TfNSW Reference: SYD23/00565/03
DPE Reference: SSD-58257960

**ADVICE ON EIS FOR WAREHOUSE 2 - ASPECT INDUSTRIAL ESTATE
MAMRE ROAD, KEMPS CREEK**

TAB A

Figure 1: Site Plan

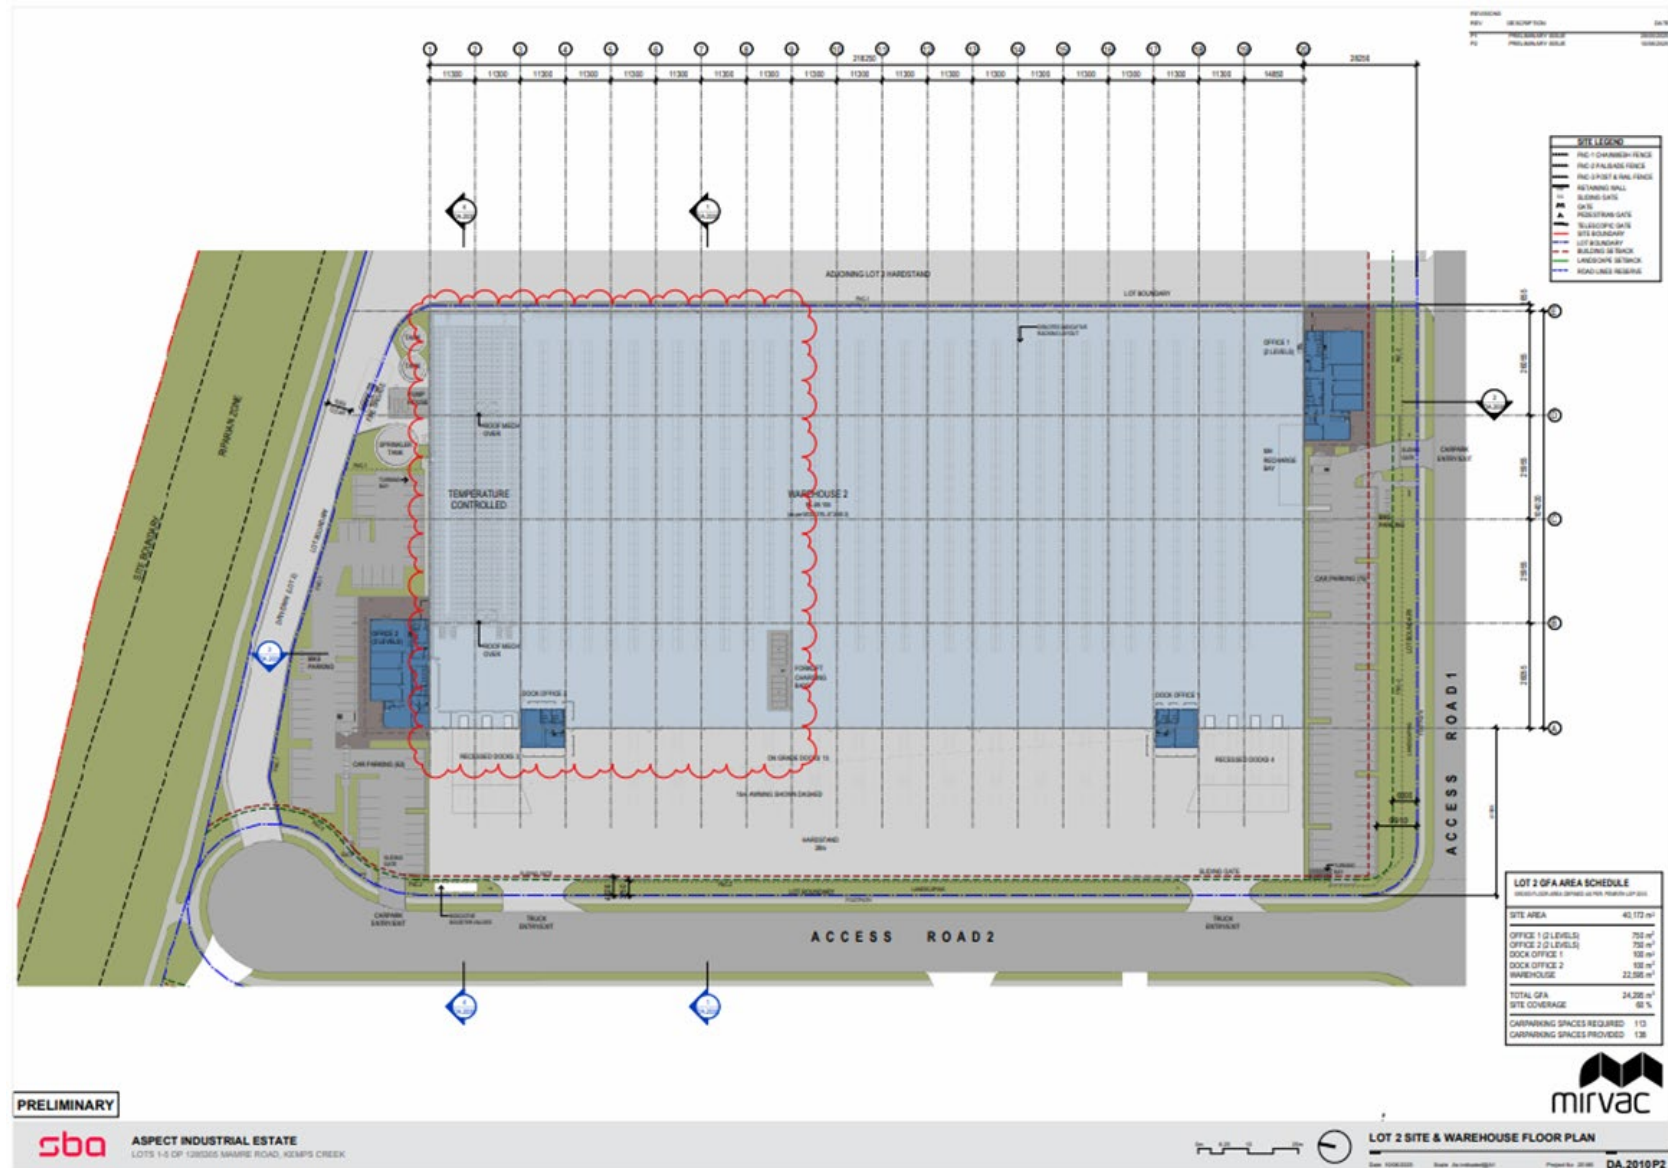
- TfNSW reiterates the previous advice provided to the applicant regarding the proposed access arrangements:
 - To promote traffic efficiency of Access Road 1, TfNSW recommend that all vehicular access including access to the carpark should be accessed via Access Road 2.

- Should the access to the carpark remain as noted from Access Road 1, considering the volume of traffic which includes a large percentage of heavy vehicles that is forecasted to enter the precinct using Access Road 1 and the proximity of the roundabout, a self-enforcing left in/ left out driveway design for the car park access from Access Road 1 would provide a much safer access arrangement for car park access.

- Furthermore, it is noted that the current access driveway design requires vehicles to have to turn through more than 90 degrees to enter the site from Access Road 1 and swept paths for this driveway have not been provided. Should the access to the car park remain as noted from Access Road 1 the driveway will need to be designed to ensure left turn in and left turn out simultaneous entry and exit movements can be achieved.
